ES Figure 9.29 - Operational Phase Road Traffic Emissions - Main HNRFI Site Annual Mean PM₁₀ Concentrations - Future Year

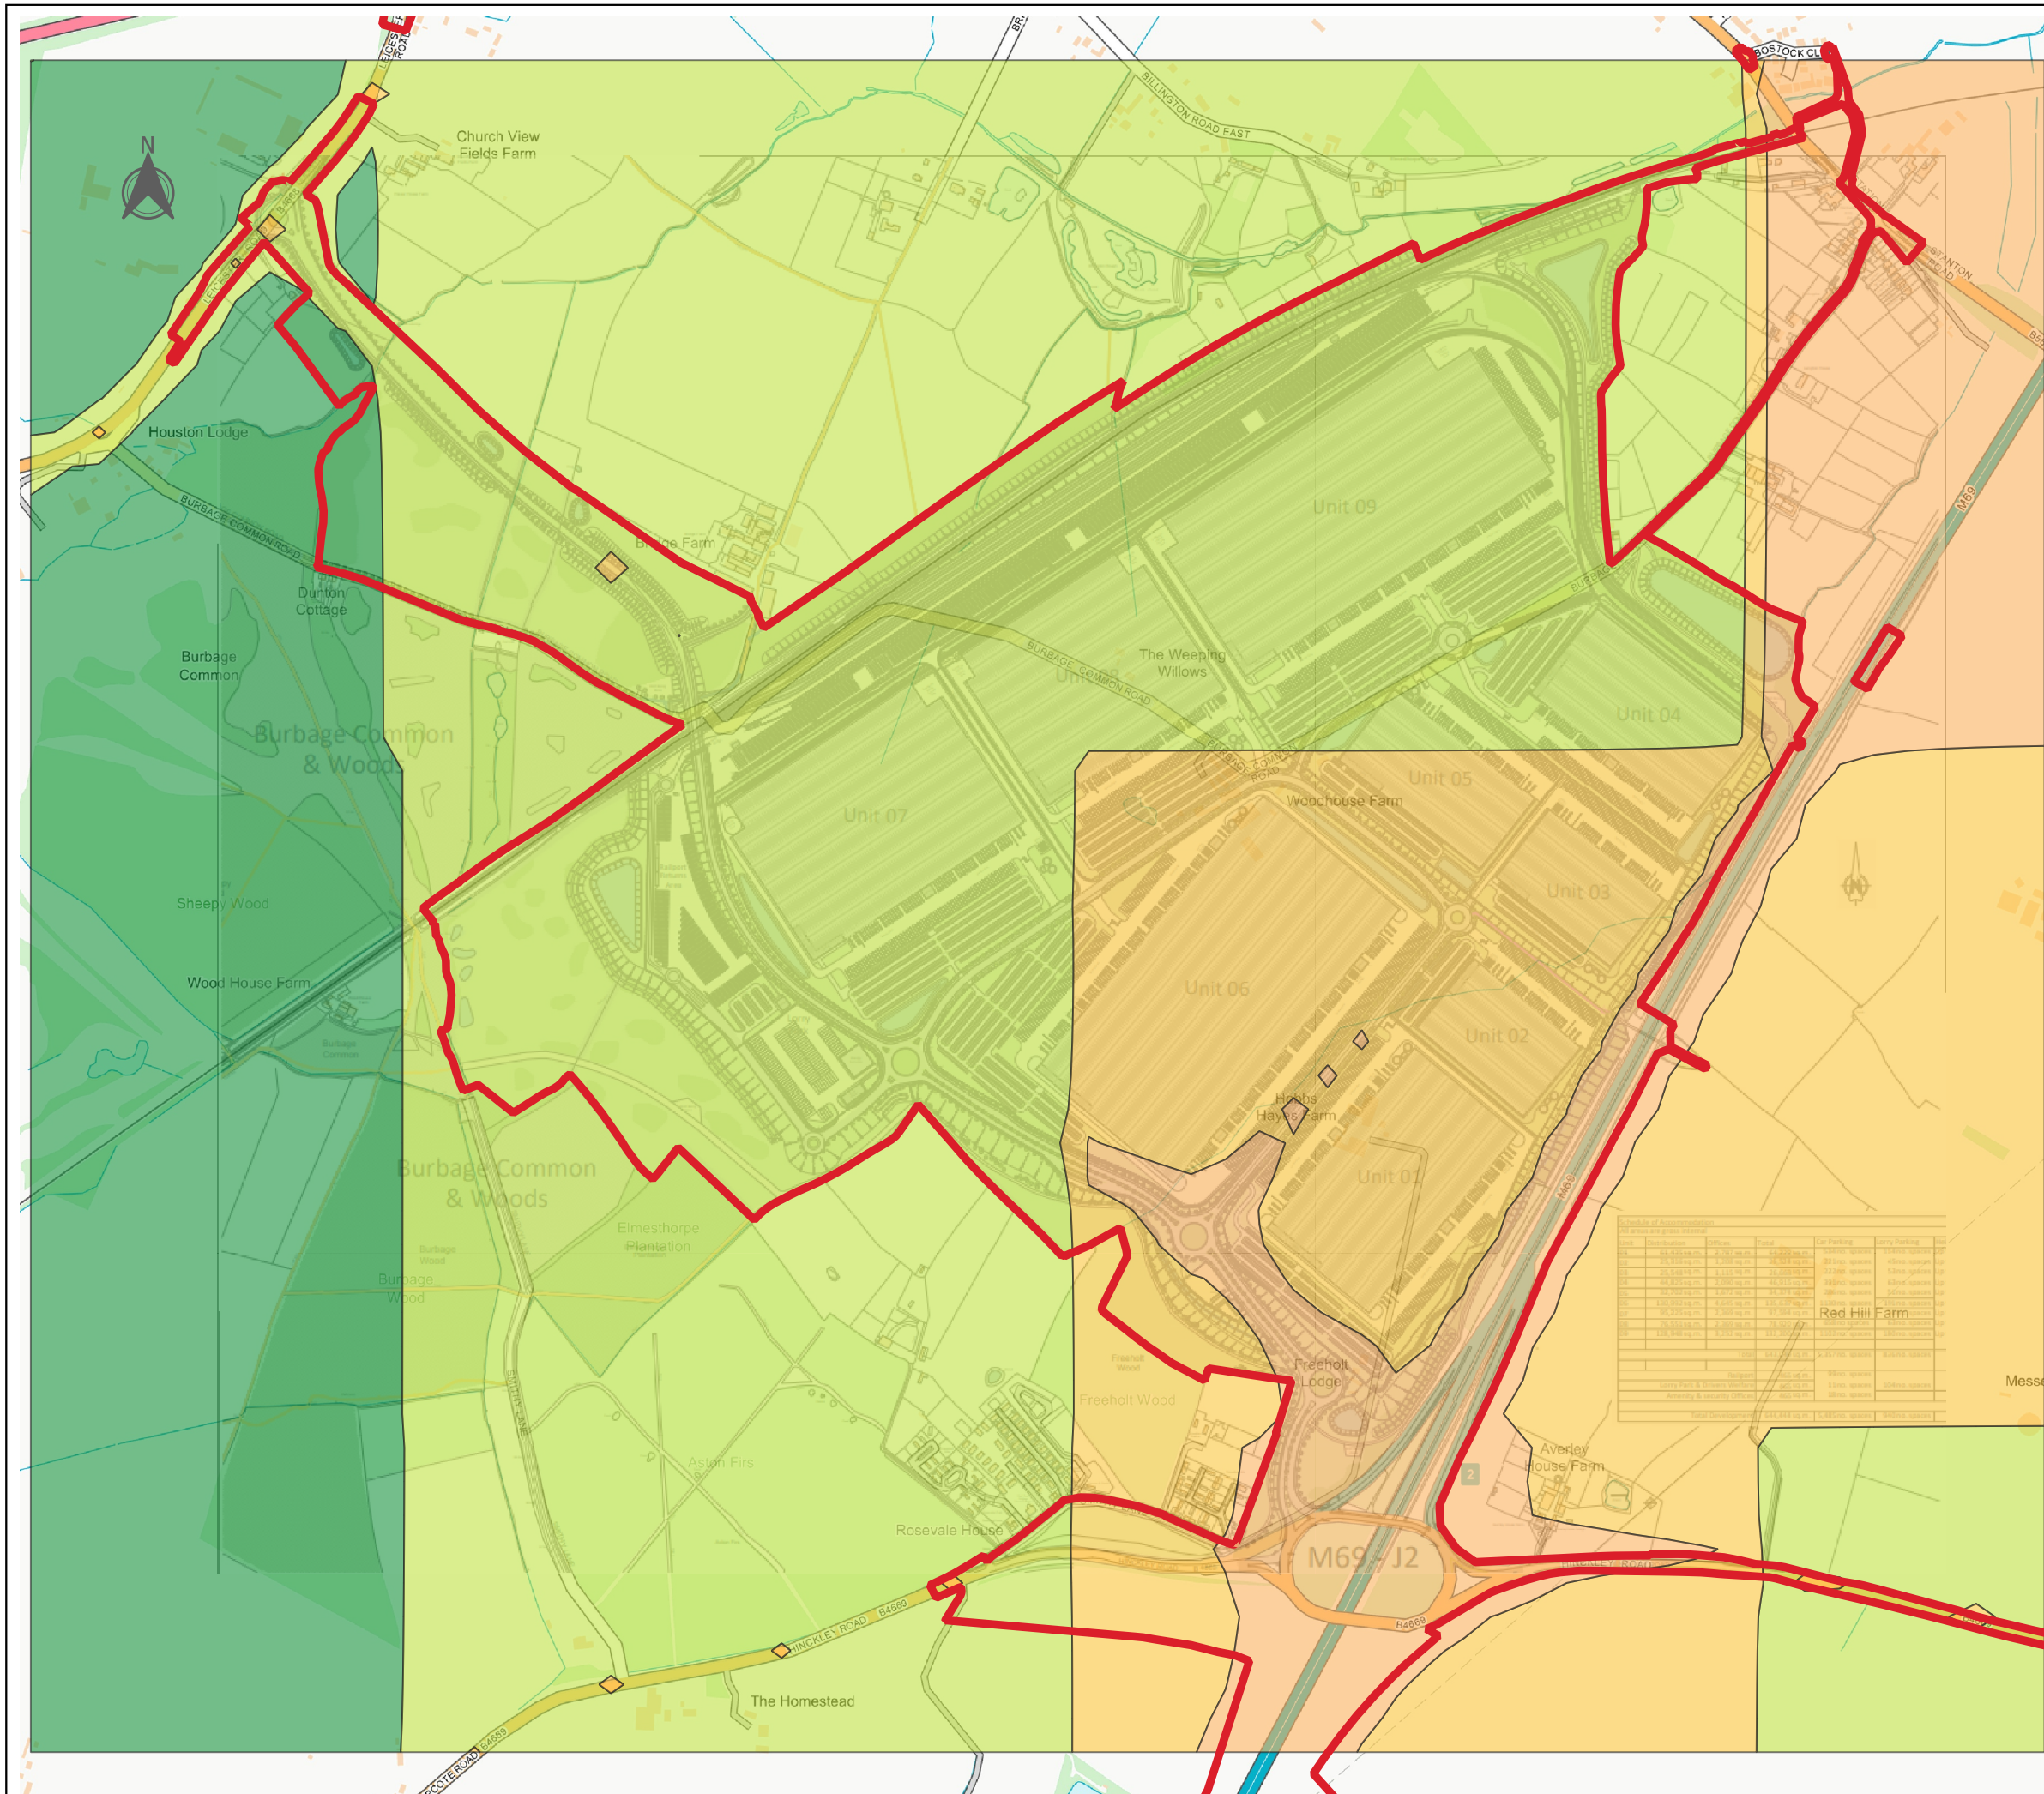
- Grading of the colour schemes of buildings is an important aspect that was promised during consultation and no longer appears to be the case.
- Air pollution: there has been an 'advertised' 'commitment' to ensure the construction is carbon neutral which I have been unable to find evidence as to how this is proposed to be achieved. There will be a marked difference in air quality.

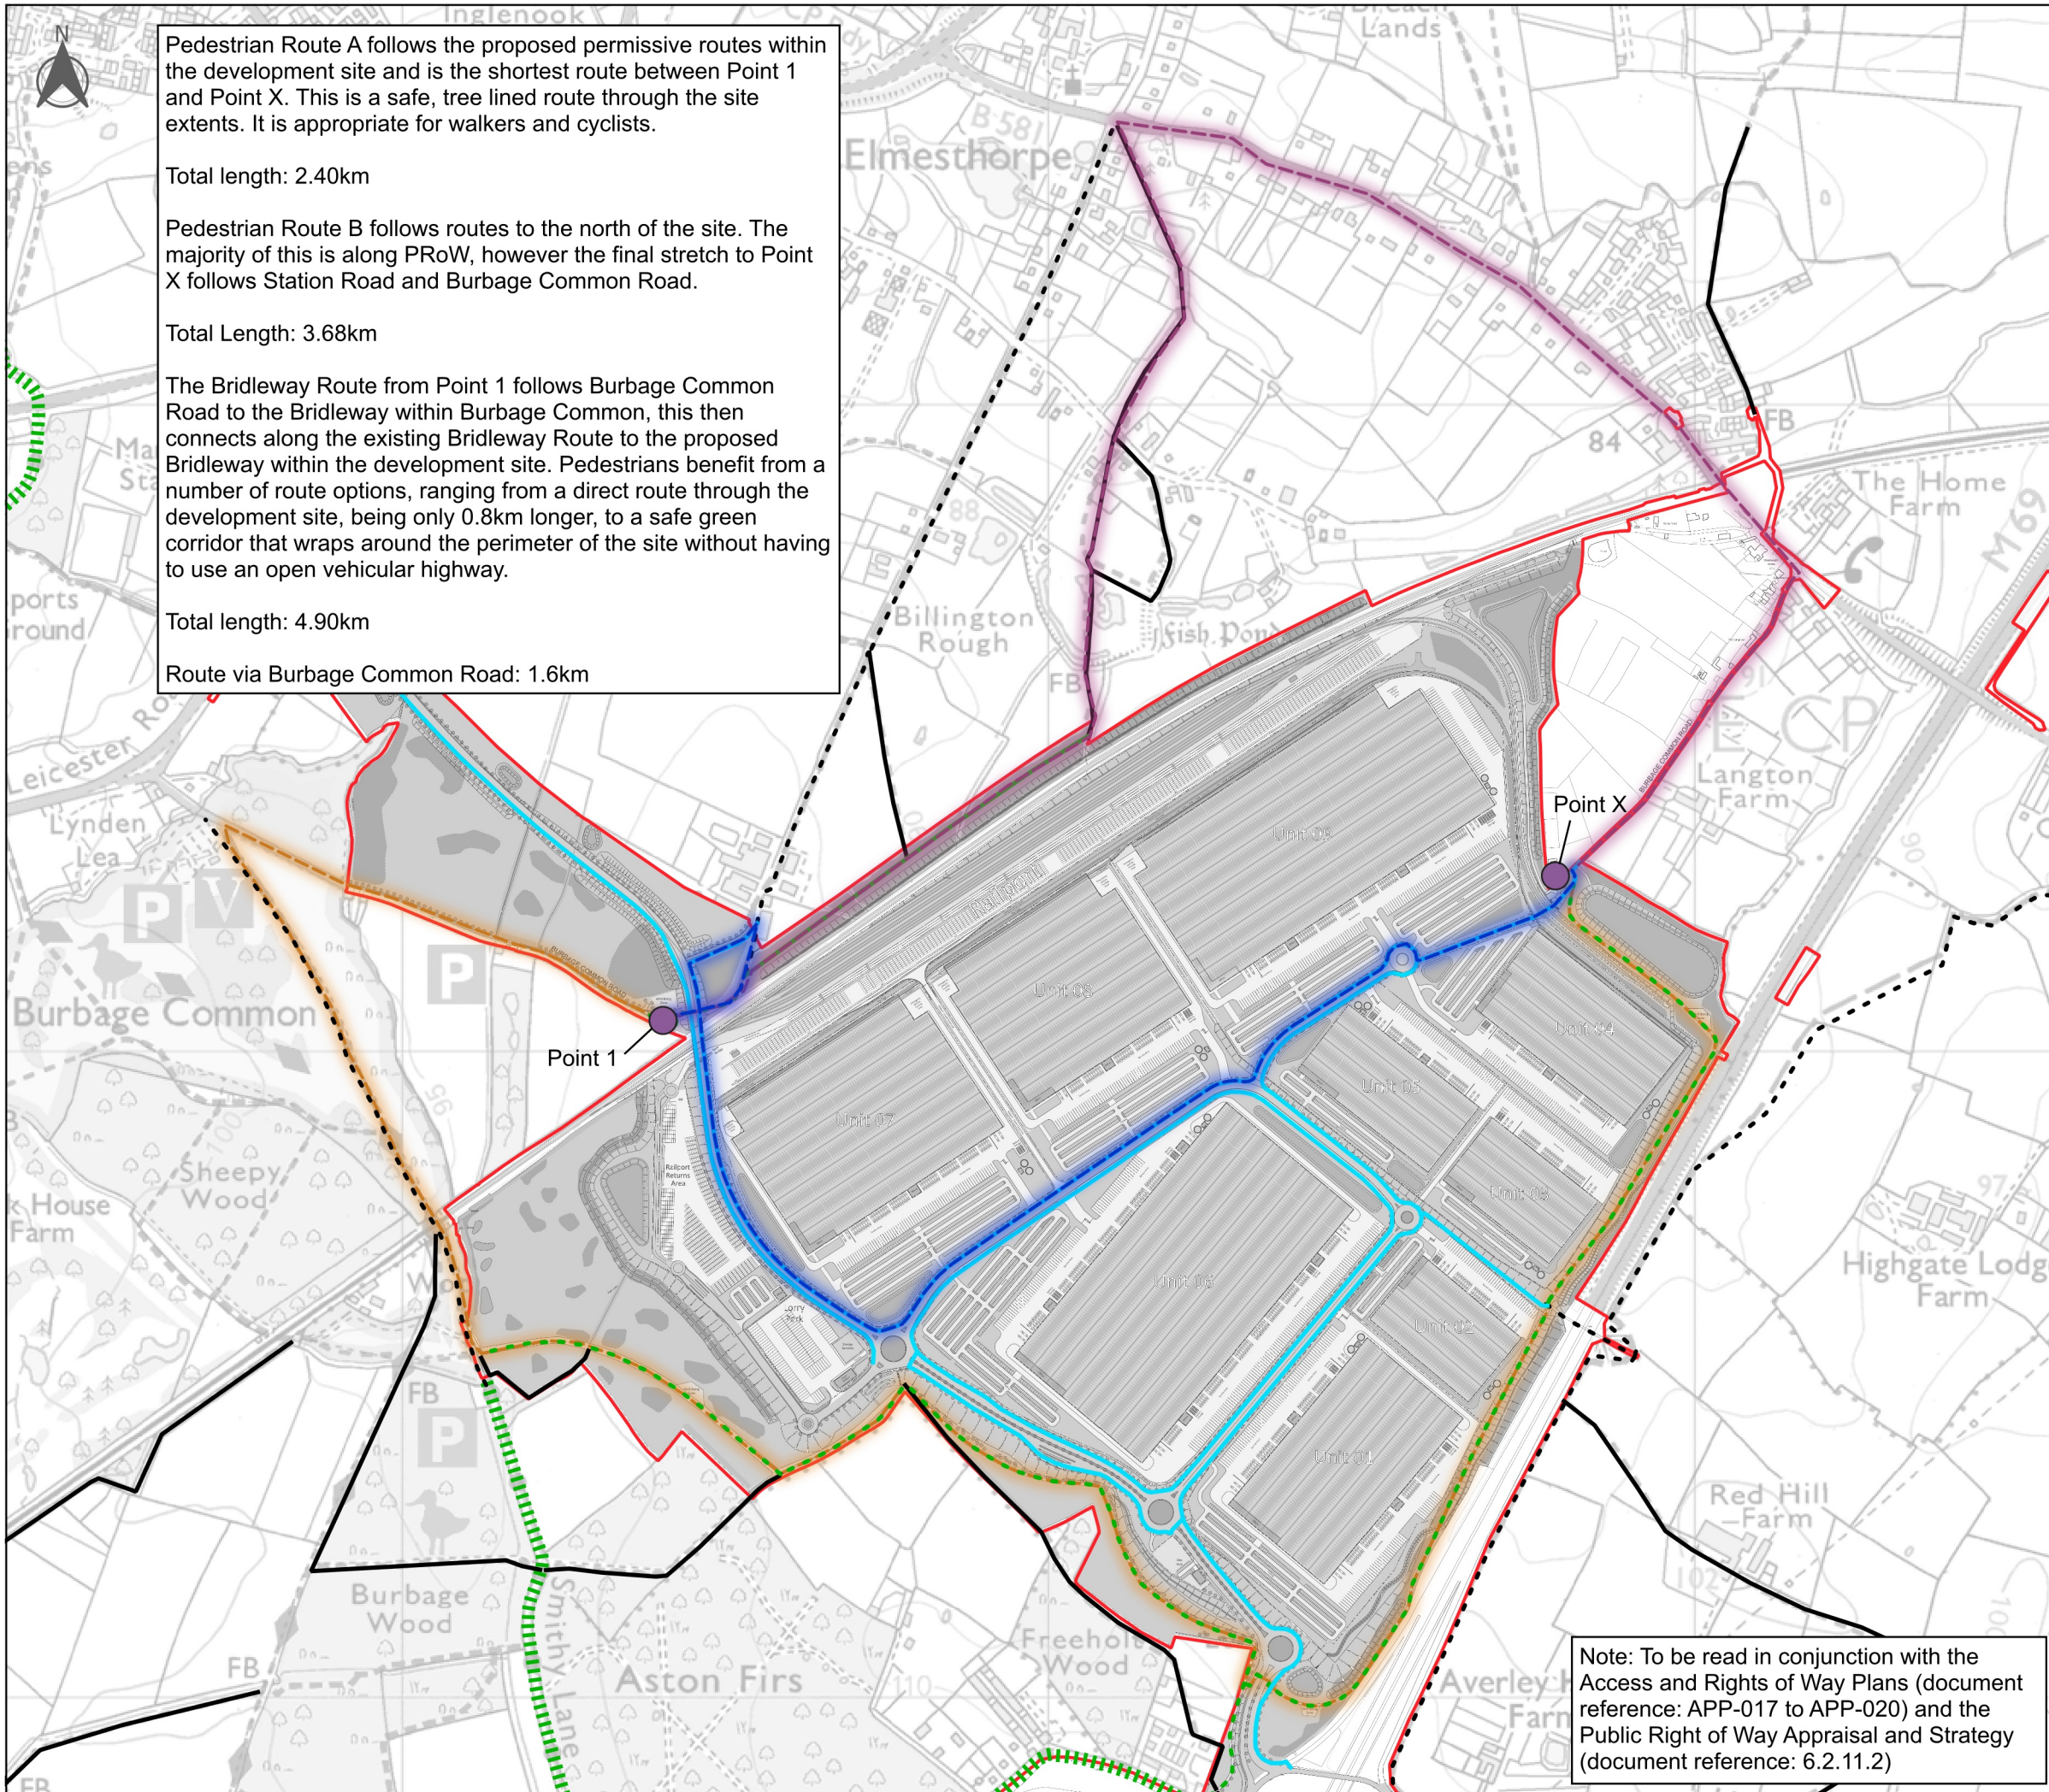
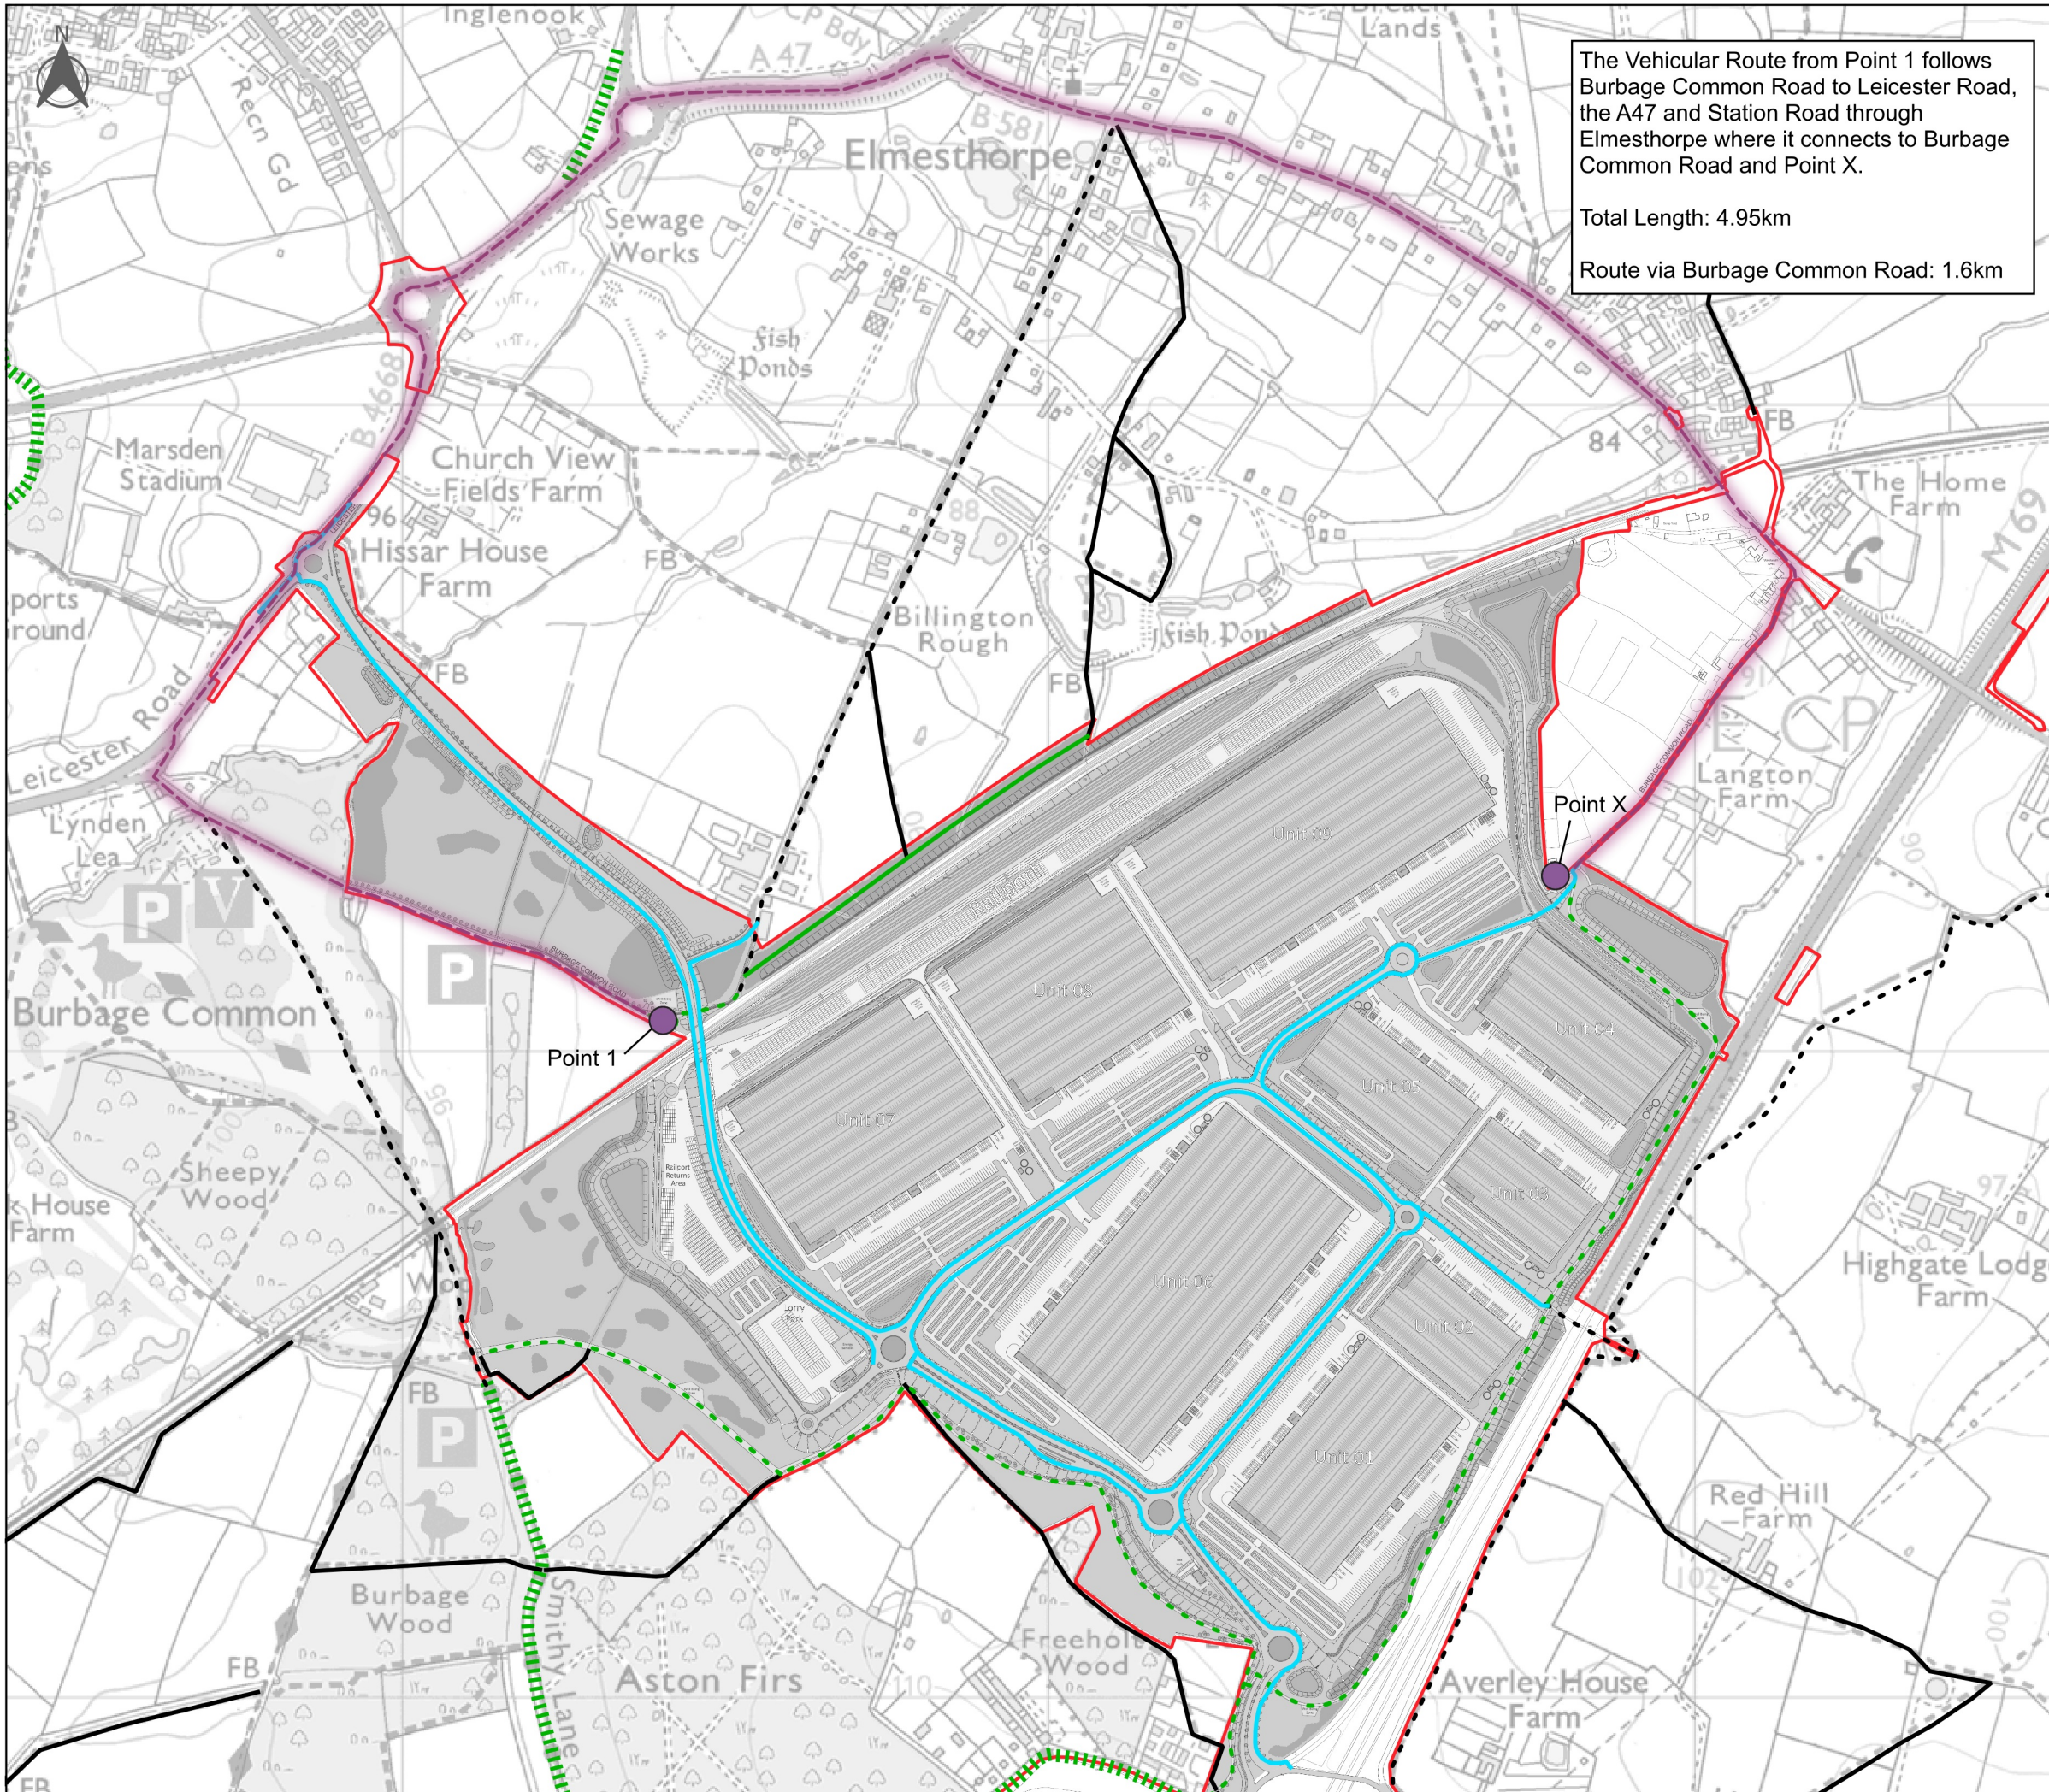
- The PROW(s) that currently link Elmesthorpe to Burbage Common SSSI (including Elmesthorpe Plantation) have been replaced by much more industrial routes. A place that was once on our doorstep now feels to have been cut off from us.
- There is a significant cluster of existing RFIs in the area, most of which are considered under utilised. It does not appear to have been researched or stress-tested that fully utilising these areas may be a more appropriate option.
- When comparing the amount of freight trains allegedly designed to use the RFI to the numbers of HGVs movements, it is very clear that this is a HGV transport hub, with rail being a secondary function (if at all). This is a warehousing application disguised as an NSIP.
